Re: Objection to MP08_0244 MOD 1 Modification Request for Mixed Used Development at 23-37 Lindfield Avenue and 11 Havilah Lane, Lindfield

1 SHADOW DIAGRAM - 21stDEC_9AM
5003 SCALE1 : 650

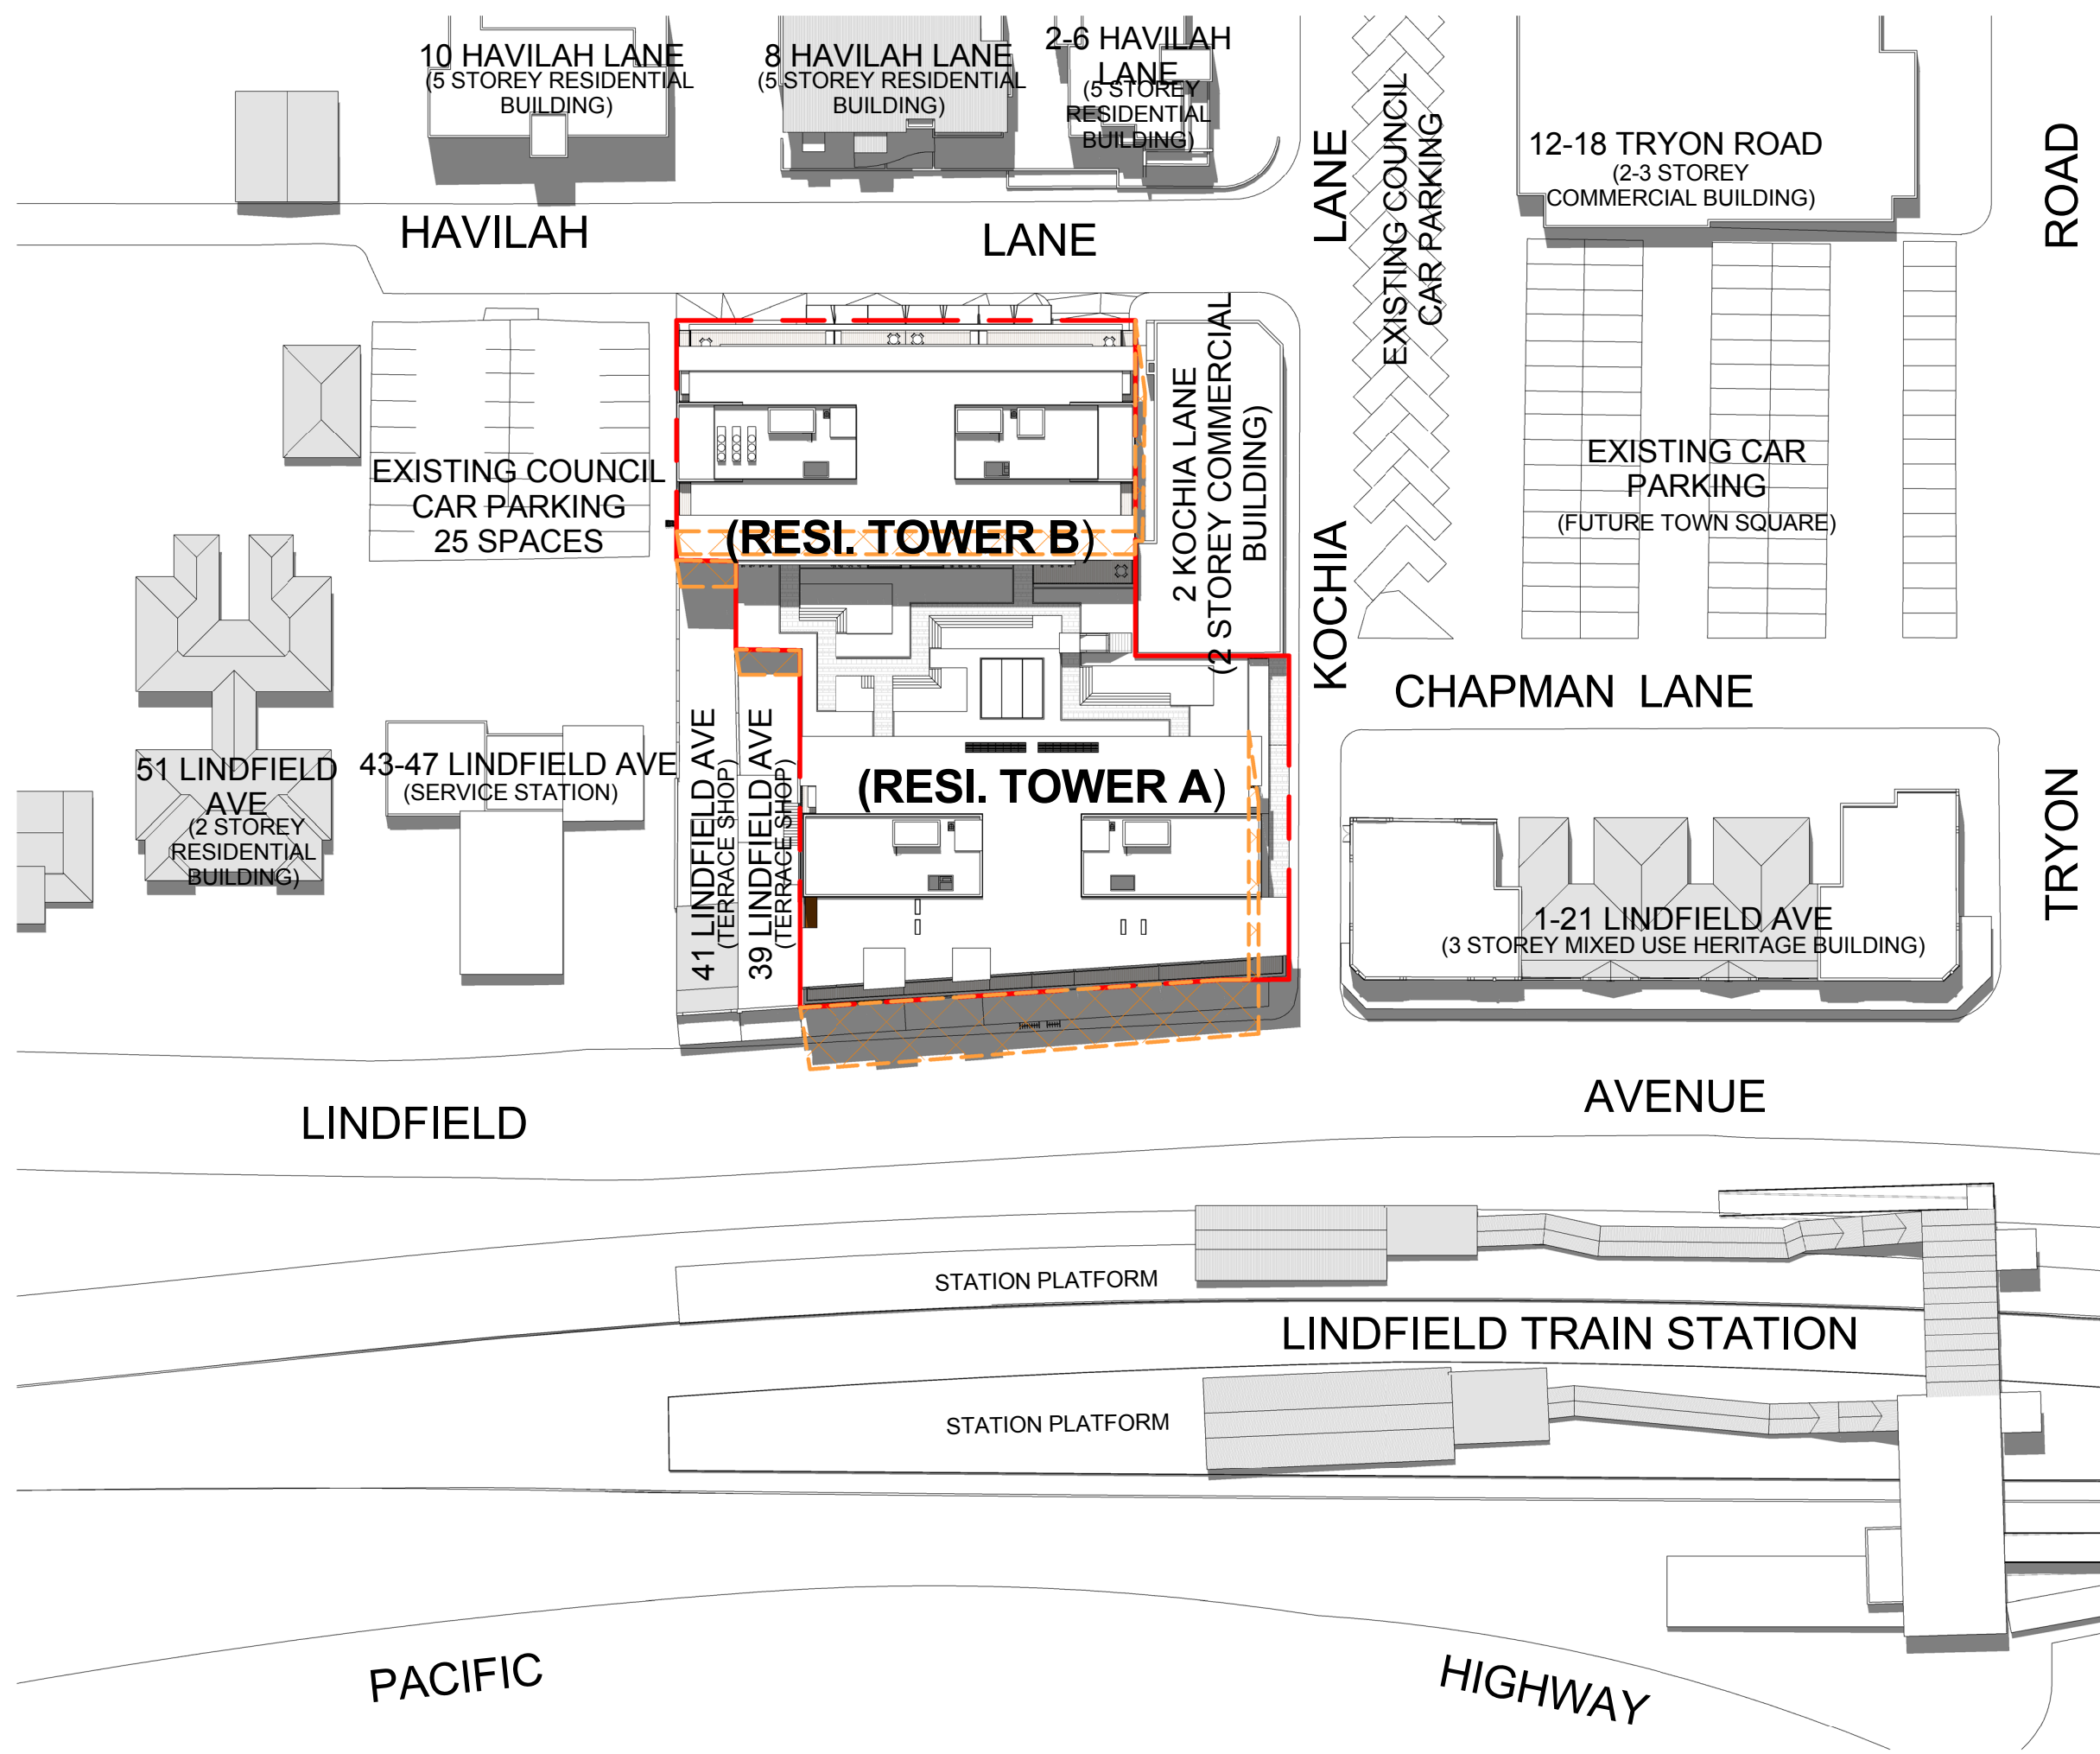
- The additional storeys create new adverse shadowing: a) for residents in the Havilah Lane apartments, particularly after 3pm b) for the popular outdoor café and central Lindfield hub area at 12 Tryon Road in afternoons, particularly in winter and c) for all commuters on the city bound Lindfield rail platform, instead of 50% of the year as approved, it will now be in shadow in the mornings 75% of the year

FIGURE 1.3 – MODIFIED SCHEME CAR PARKING

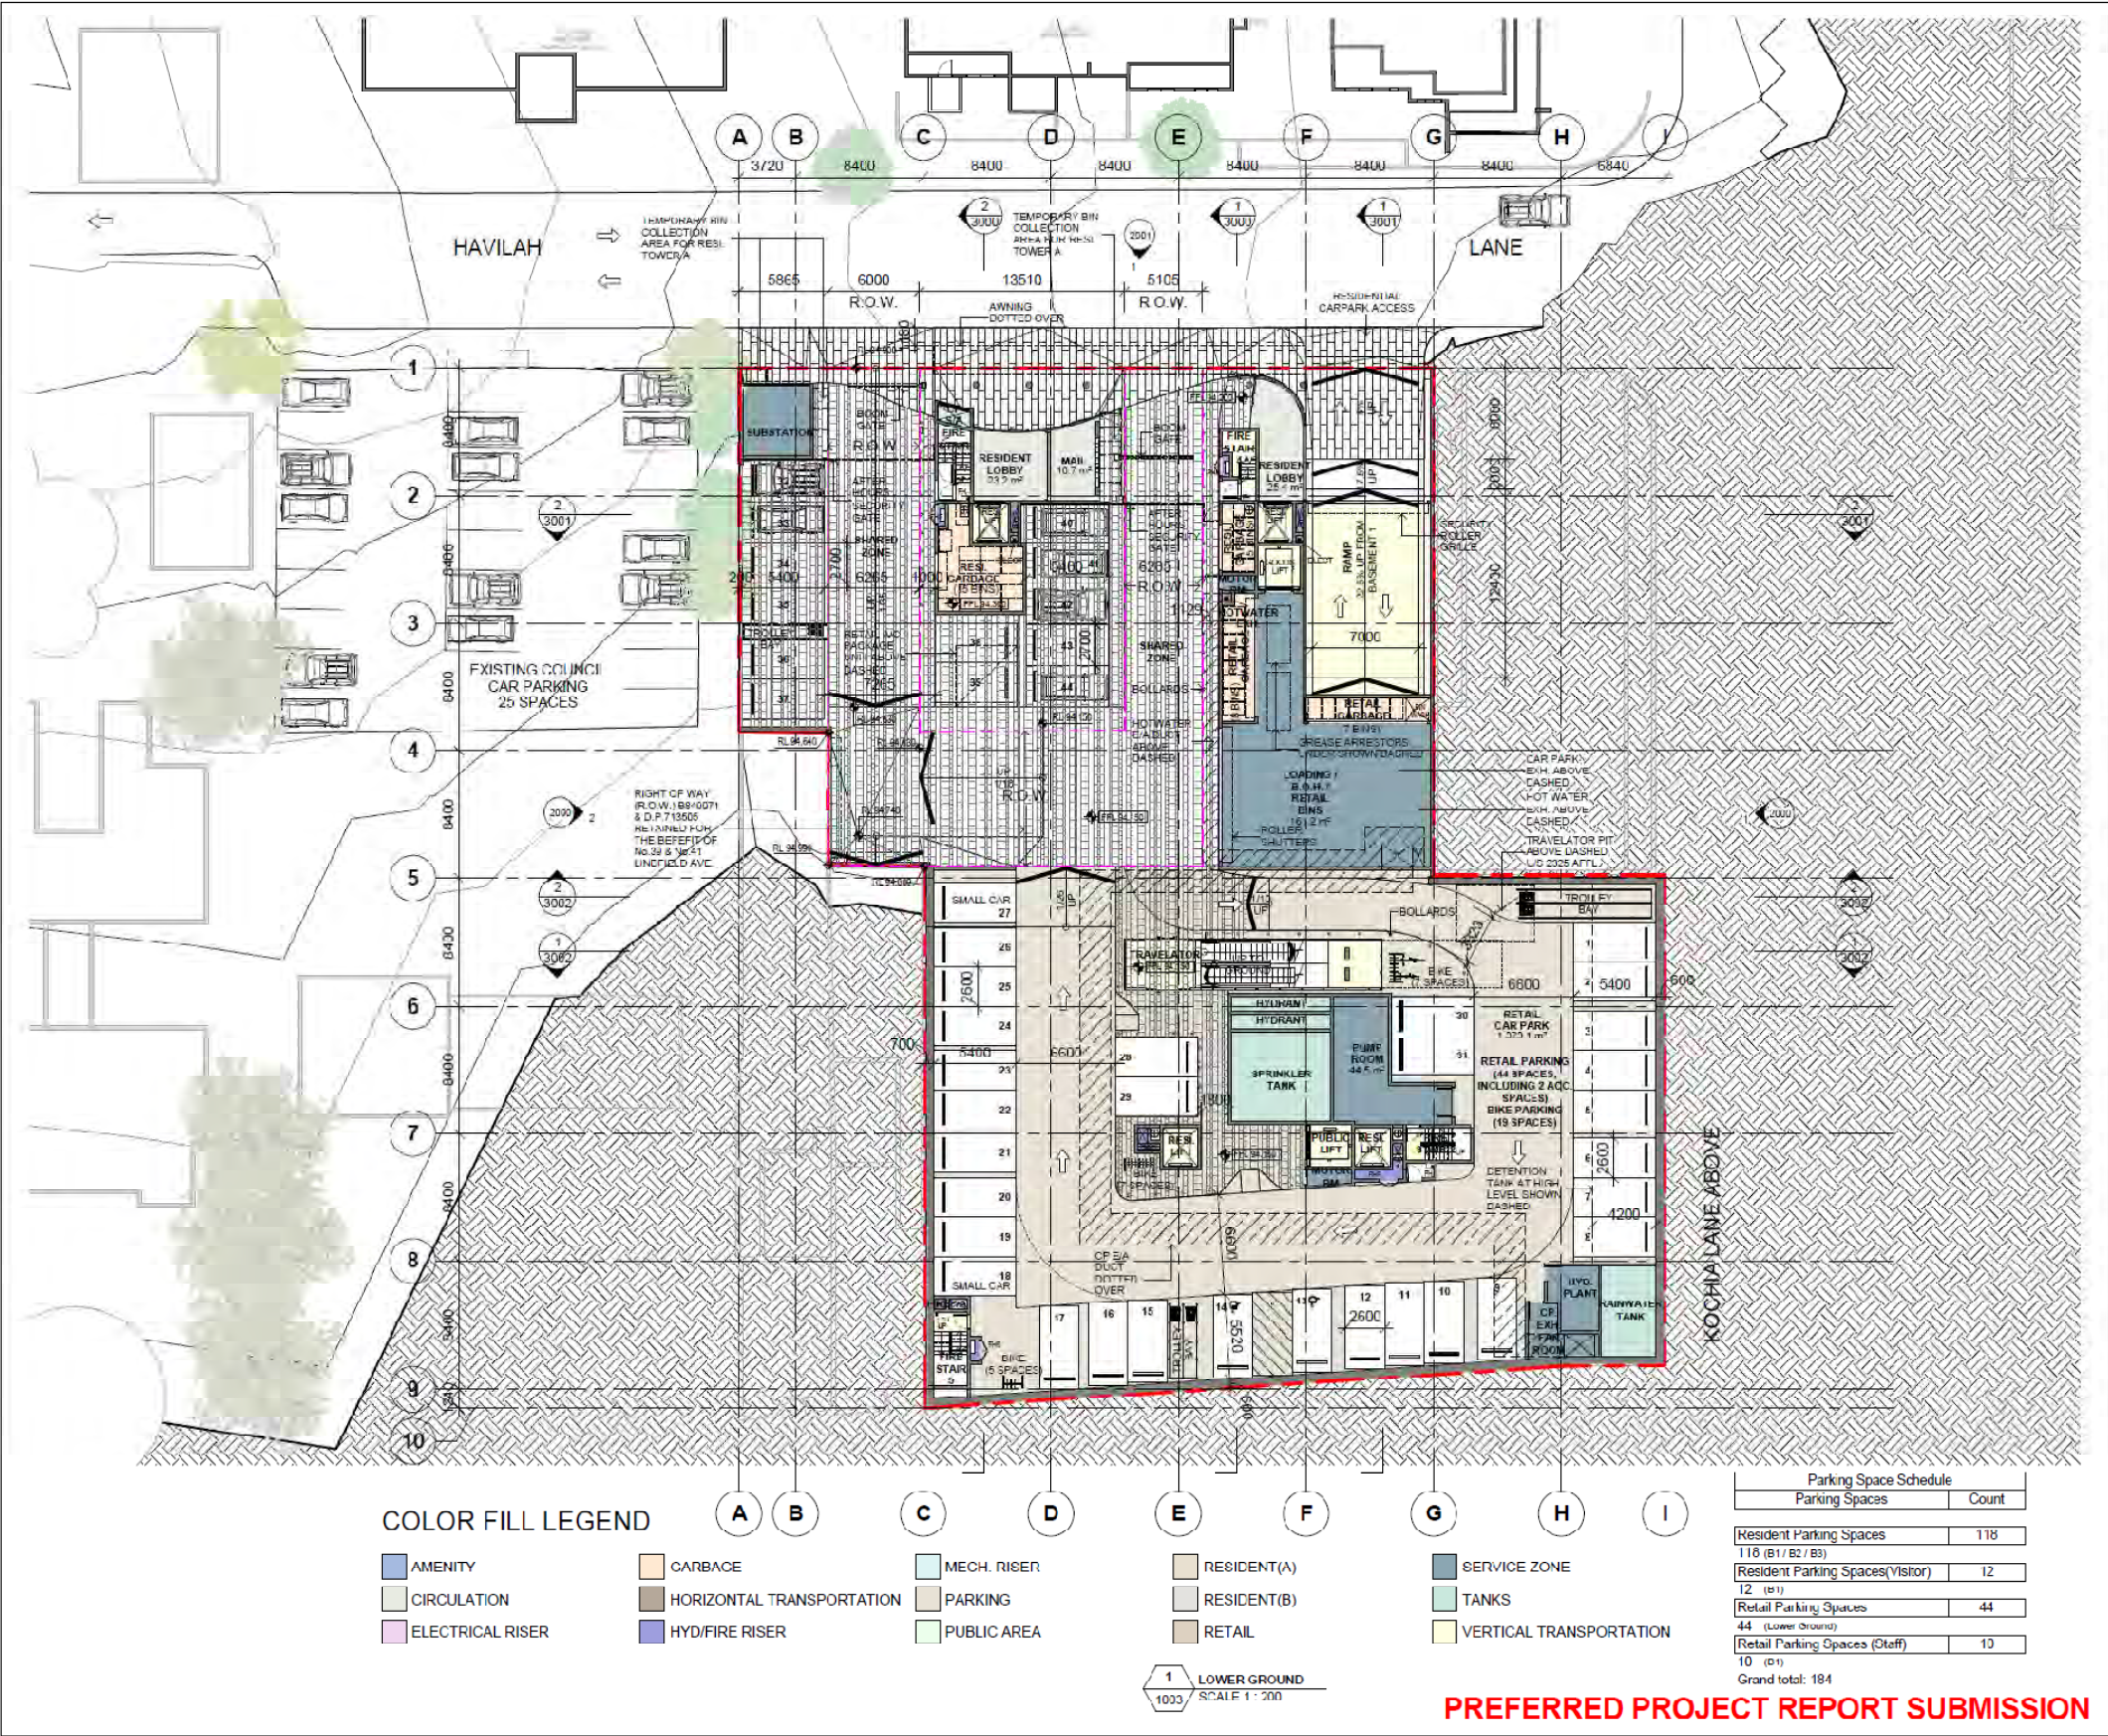
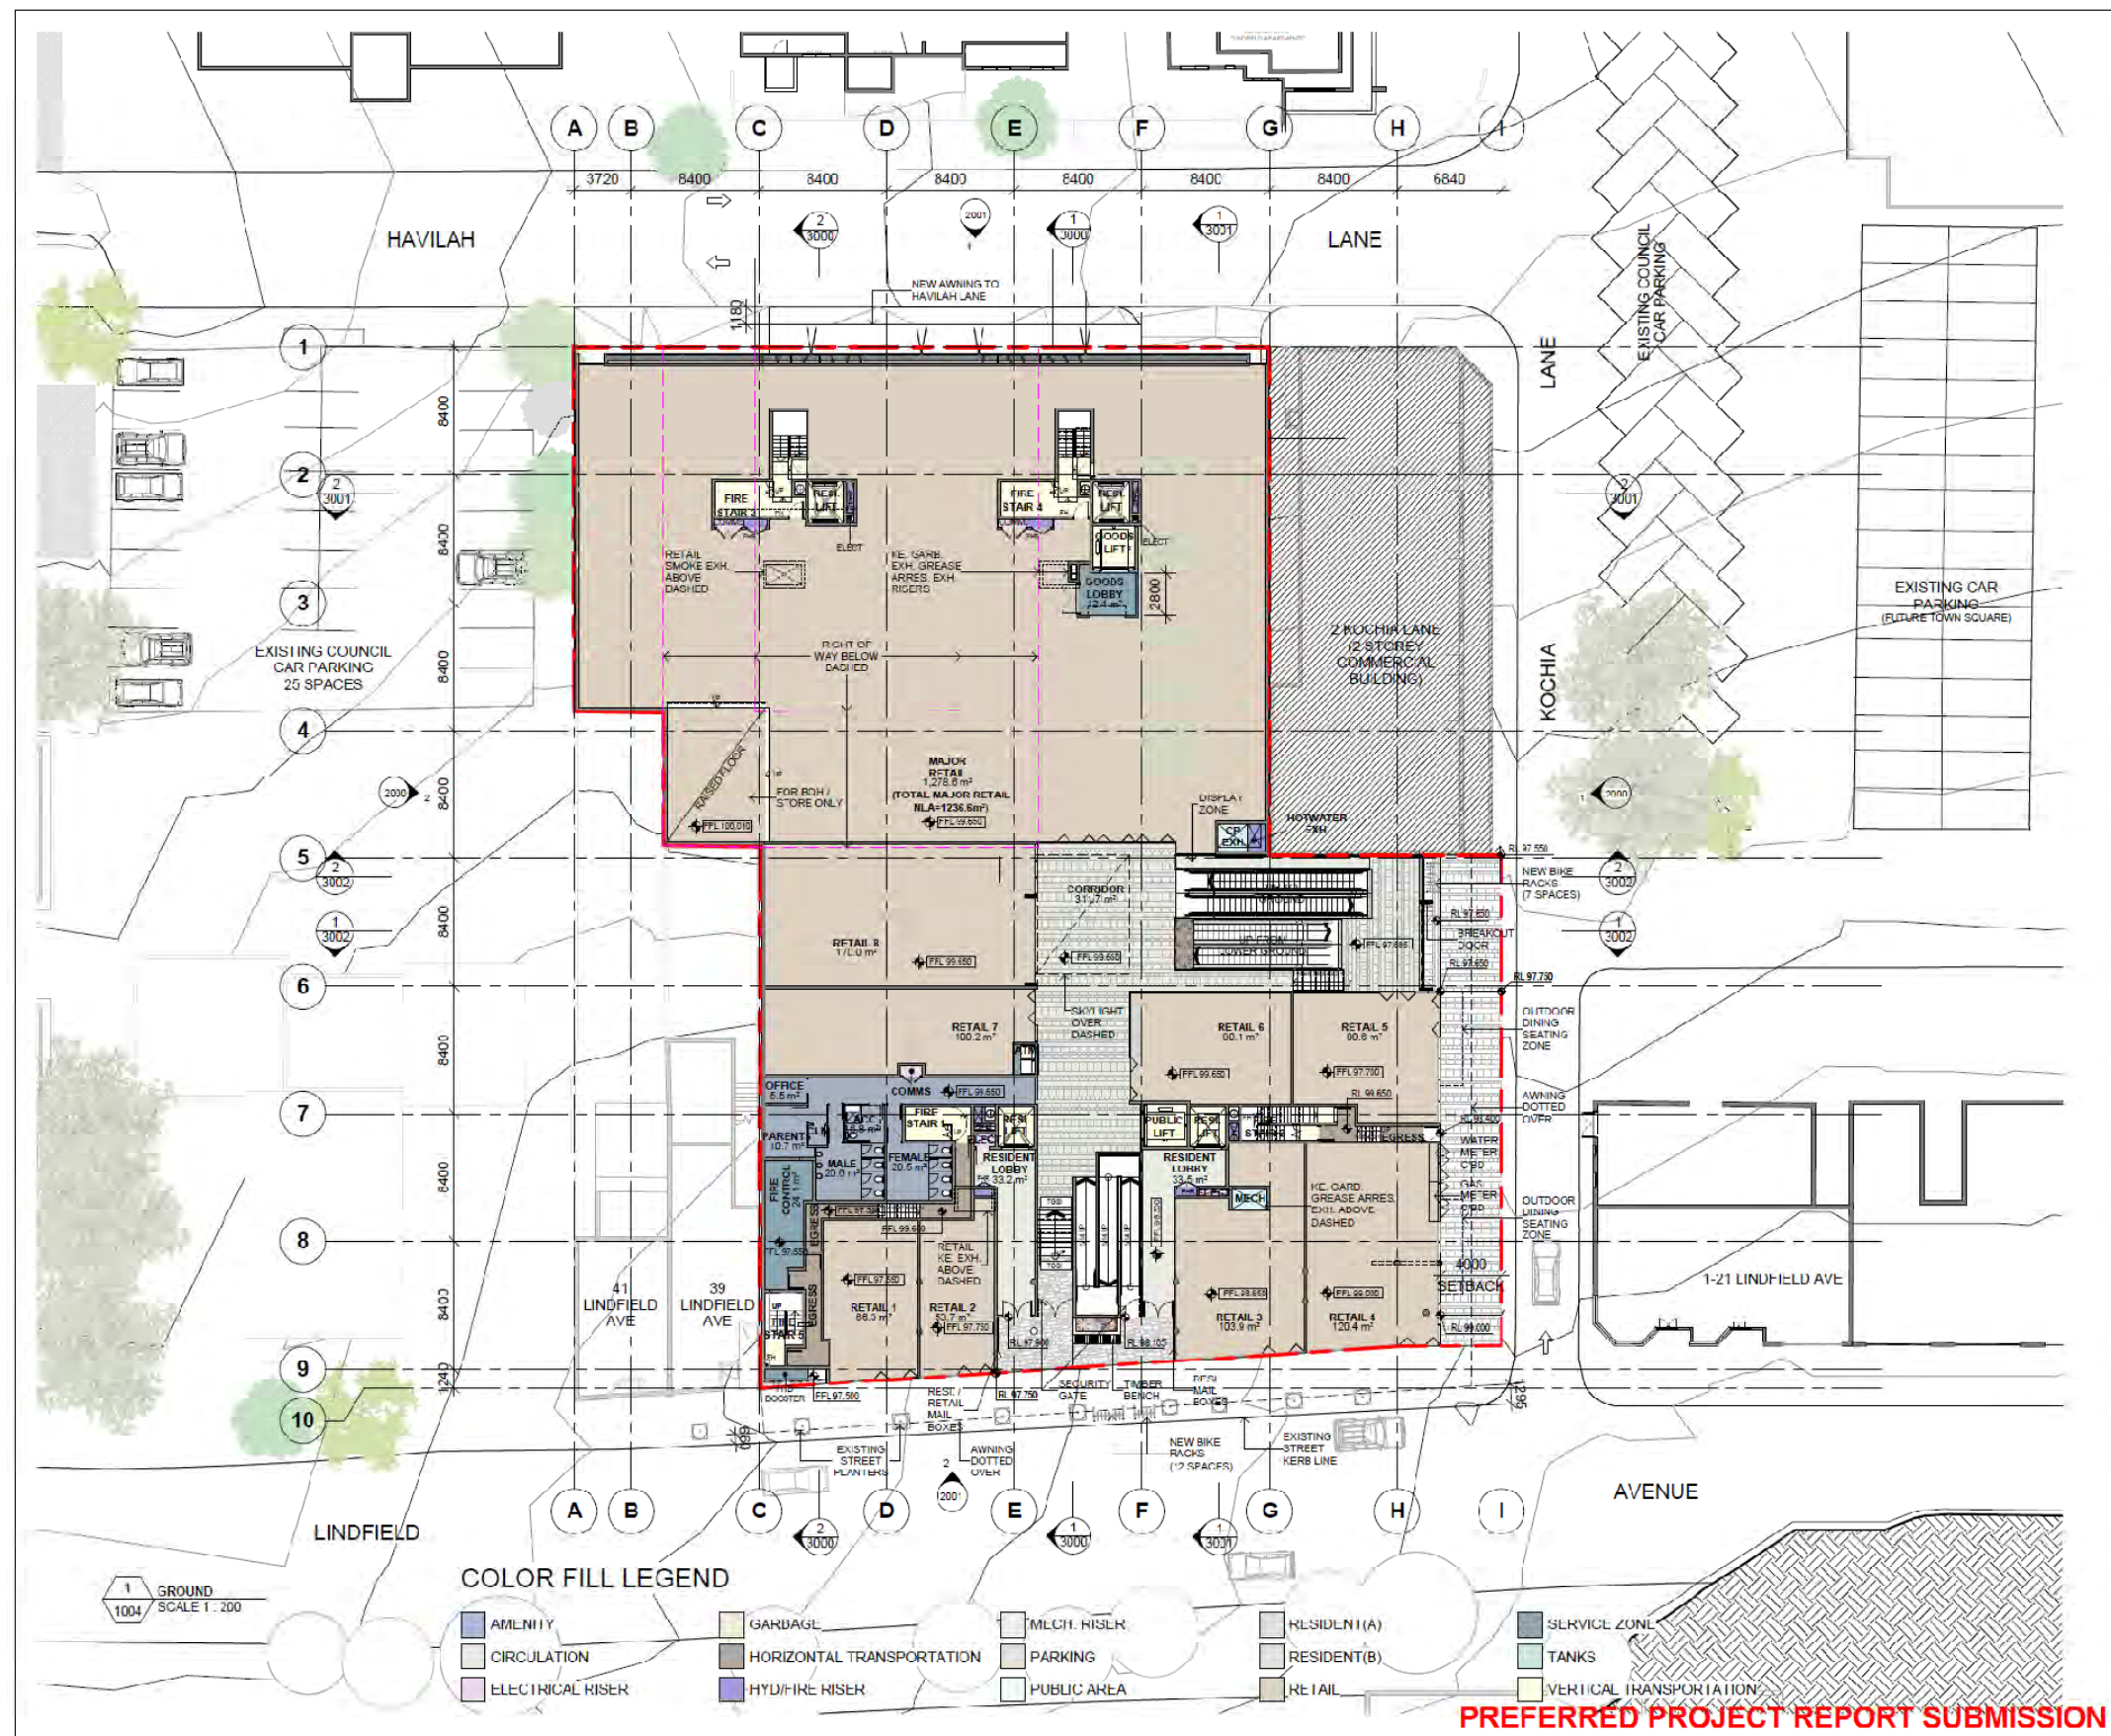
- Car spaces were identified as inadequate for the retail component and this has not been addressed relative to the remaining retail space proposed. The 25 car spaces counted as part of council's car park are also now highly uncertain due to the proposed rezoning and potential redevelopment.
